Engineers Comments Regarding Surface Water Drainage

Application Reference:	AL/6/25/DOC	Reviewer Reference:	ADC/SB
Planning Officer:	Hannah Kersley	Date of Review:	21/02/2025
Site Name:	8 Autumn Gate Hook Lane Aldingbourne PO20 3TE		
Application Description:	Approval of details reserved by condition imposed under reference AL/75/24/HH relating to condition number 4 - surface water drainage scheme.		
Assessment Number:	1 of 2

Response	Condition 4: Objection
-----------------	-------------------------------

PROPOSED DRAINAGE STRATEGY (scale 1:100)

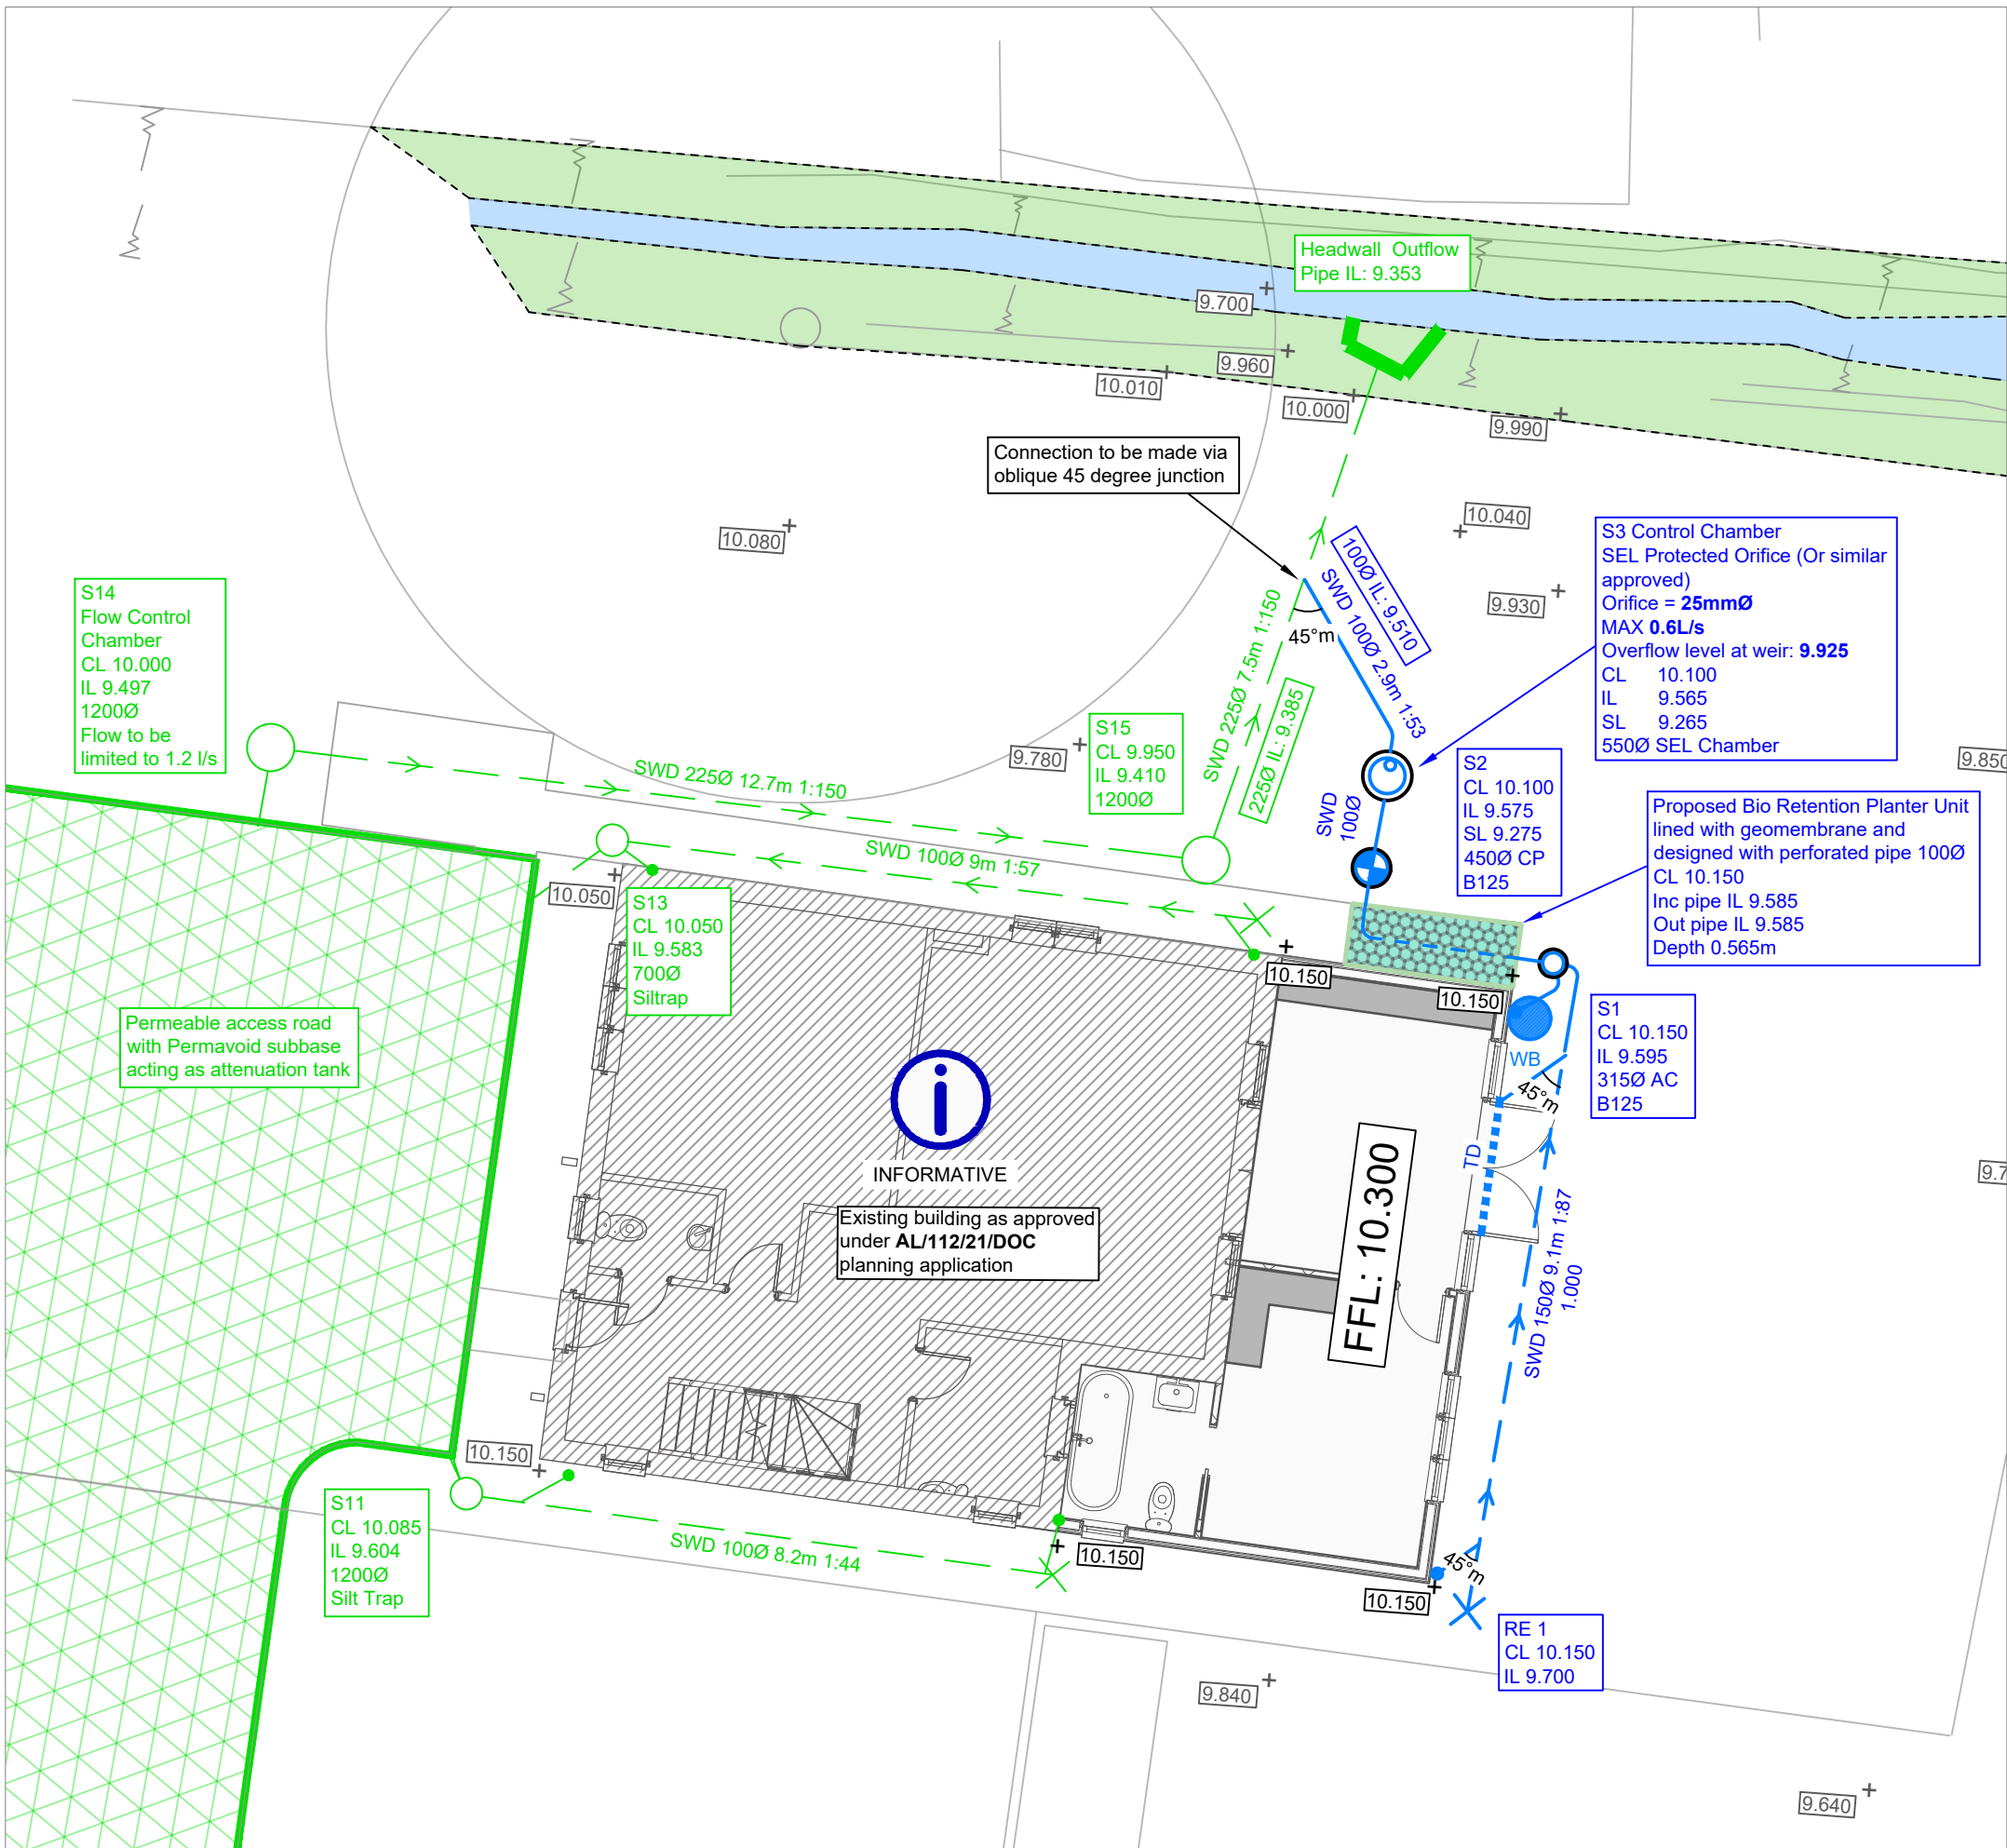
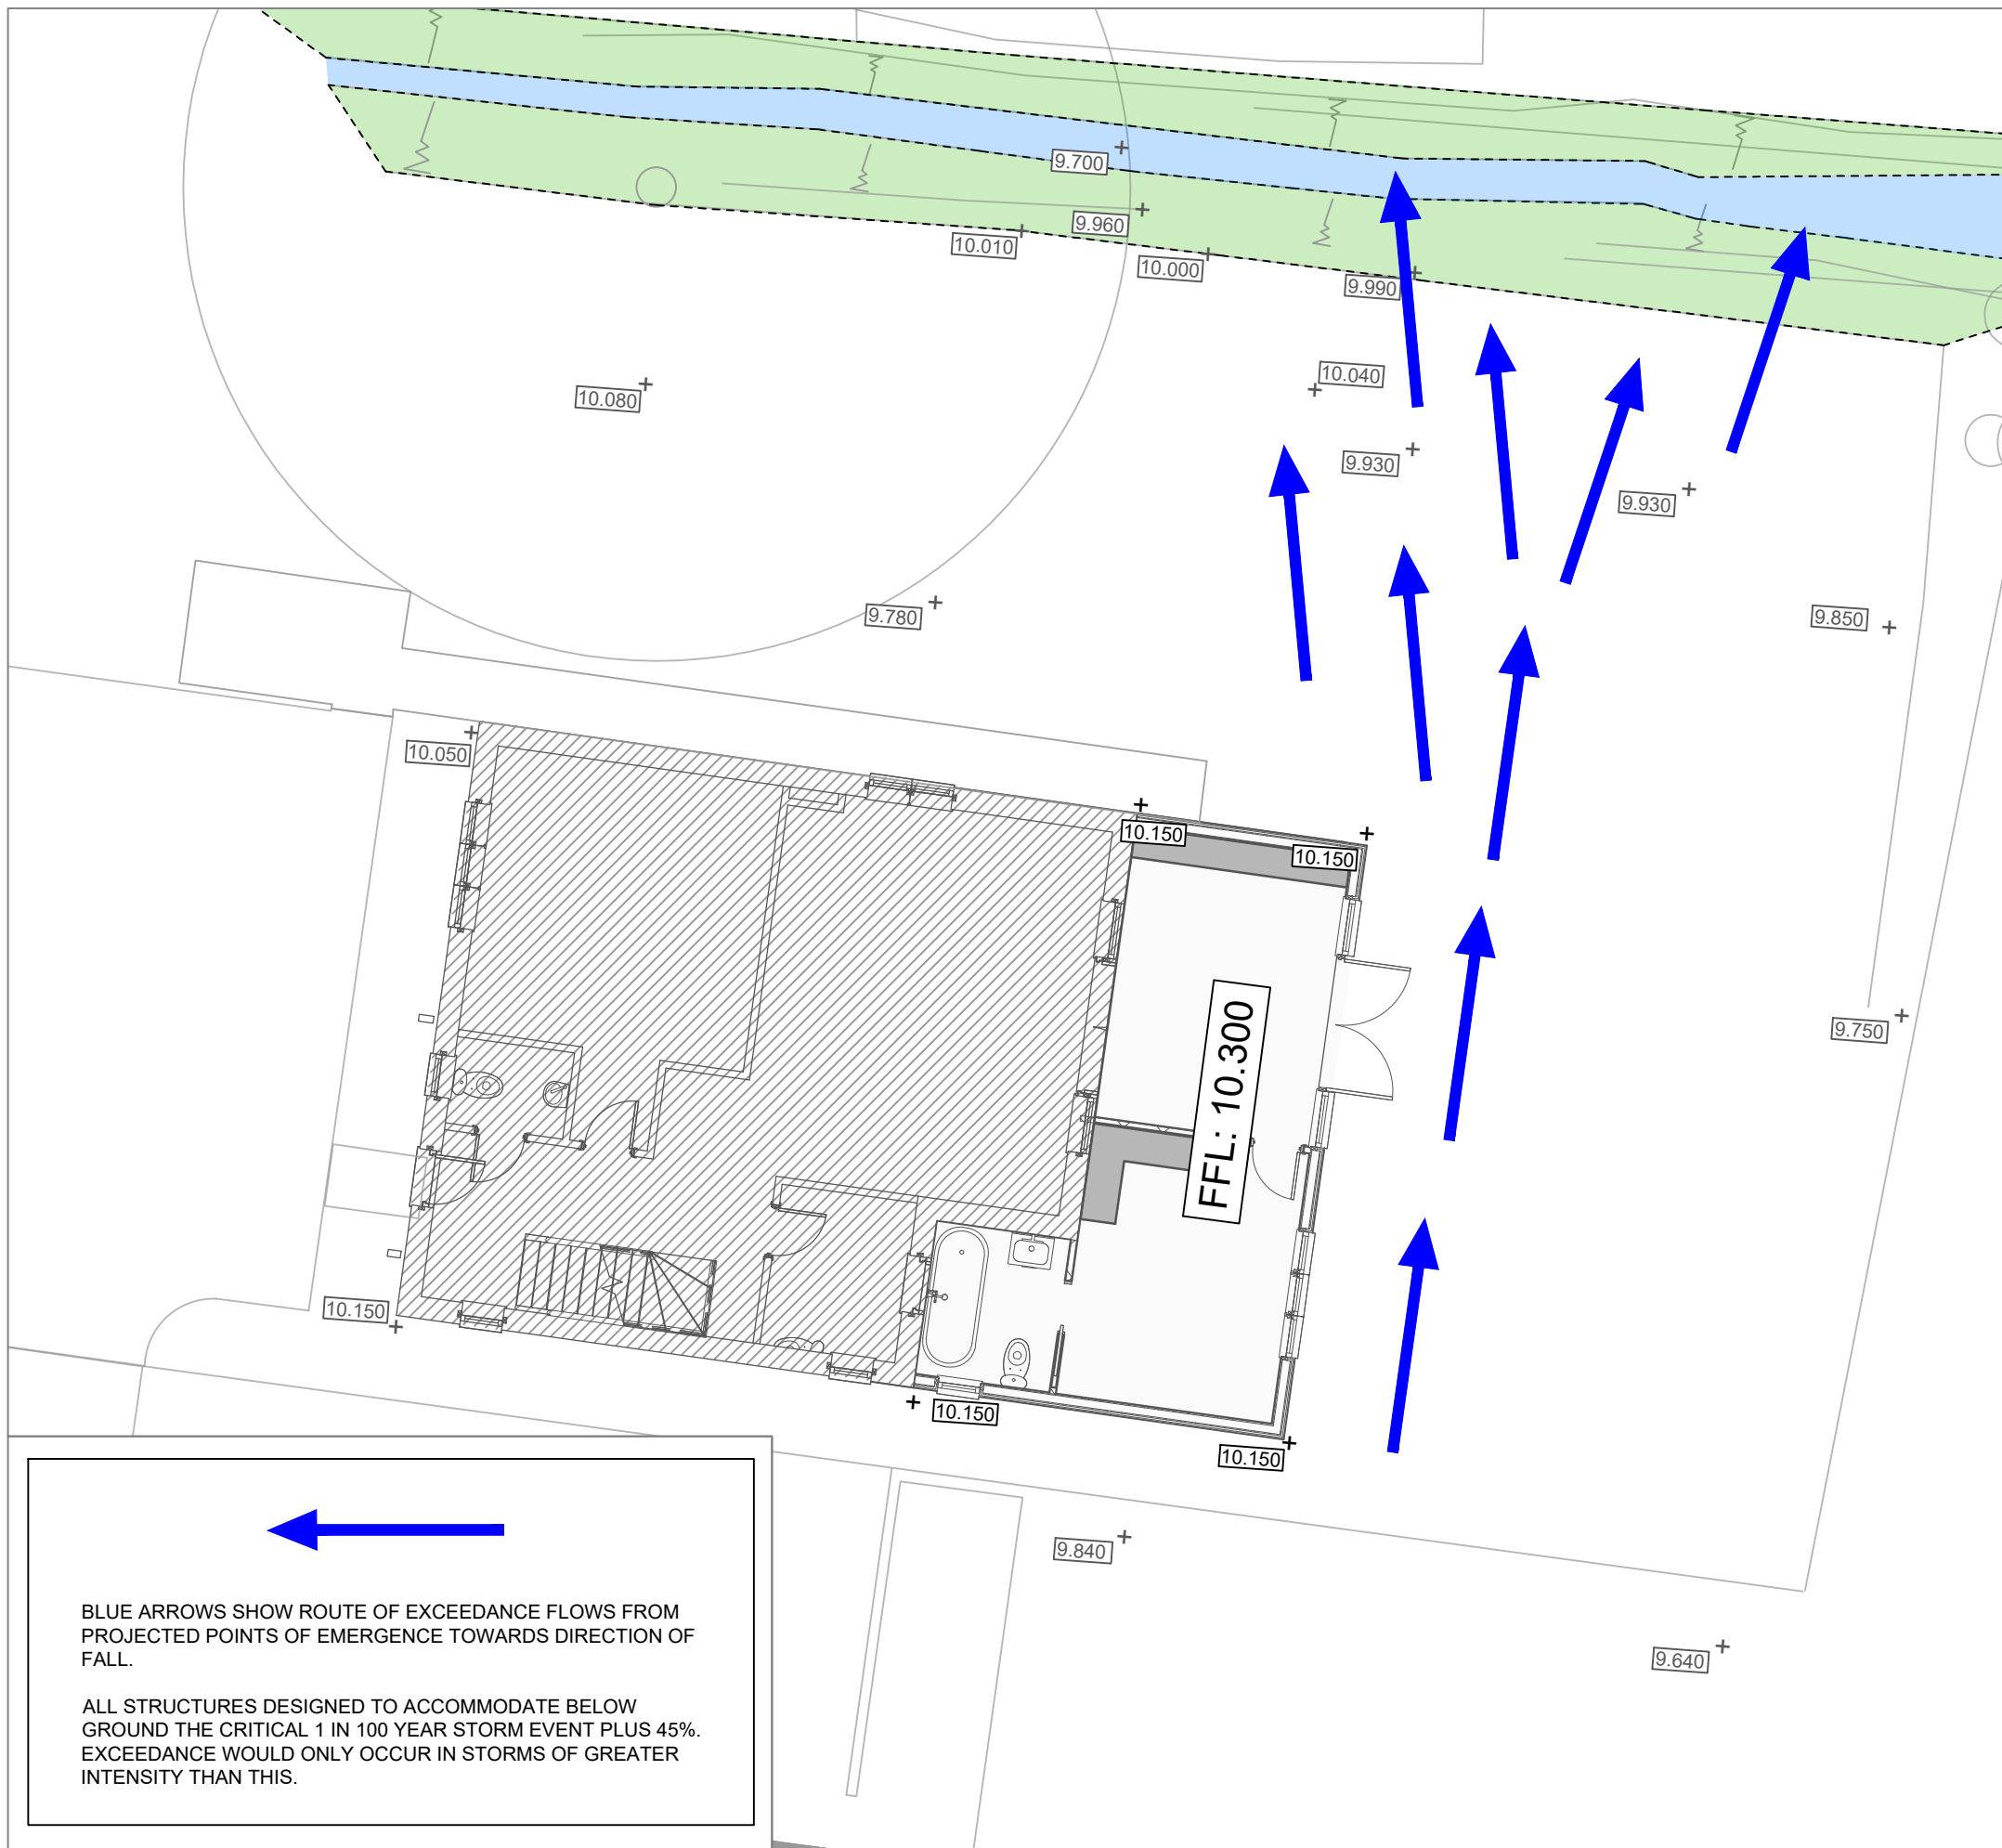
The applicant has submitted the surface water drainage design and supporting information for the wider Imperial Homes development that 8 Autumn Gate forms part of. Whilst much of this data is useful, it needs a supporting statement, analysis and an updated layout to show how it may be used for the proposed extension to 8 Autumn Gate.

The applicant must demonstrate how they will drain surface water from the proposed extension without increasing flood risk. If they intend to connect to the existing system, then they must show this on a drainage layout and evidence that there is sufficient capacity in the system to receive the additional flow. This may be due to an allowance for urban creep, or due to spare capacity in the system.

- ☐ The proposed design within the proposed site layout. **Specific to the proposed extension**
- ☒ Existing and proposed levels.
- ☐ Exceedance flow management routes.
- ☒ Details of connections to watercourses and sewers.
- ☒ Maintenance access and any arisings storage and disposal arrangements.

- ☐ It can be clearly determined what a pipe's diameter, pipe materials, gradients, flow directions and invert levels are from the plans. **Specific to the proposed extension**

- ☐ It can be clearly determined what an inspection chamber or manhole's cover level, invert level, cover loading grade and sump depth (where applicable) are from the plans. **Specific to the proposed extension**

- ☐ All infiltration or attenuation features (including permeable paving) are clearly labelled with their dimensions, invert/base levels and cover levels. **Specific to the proposed extension**

- ☐ Control structures are labelled with discharge rates, hydraulic head, invert and cover levels and ideally model number. **Specific to the proposed extension**
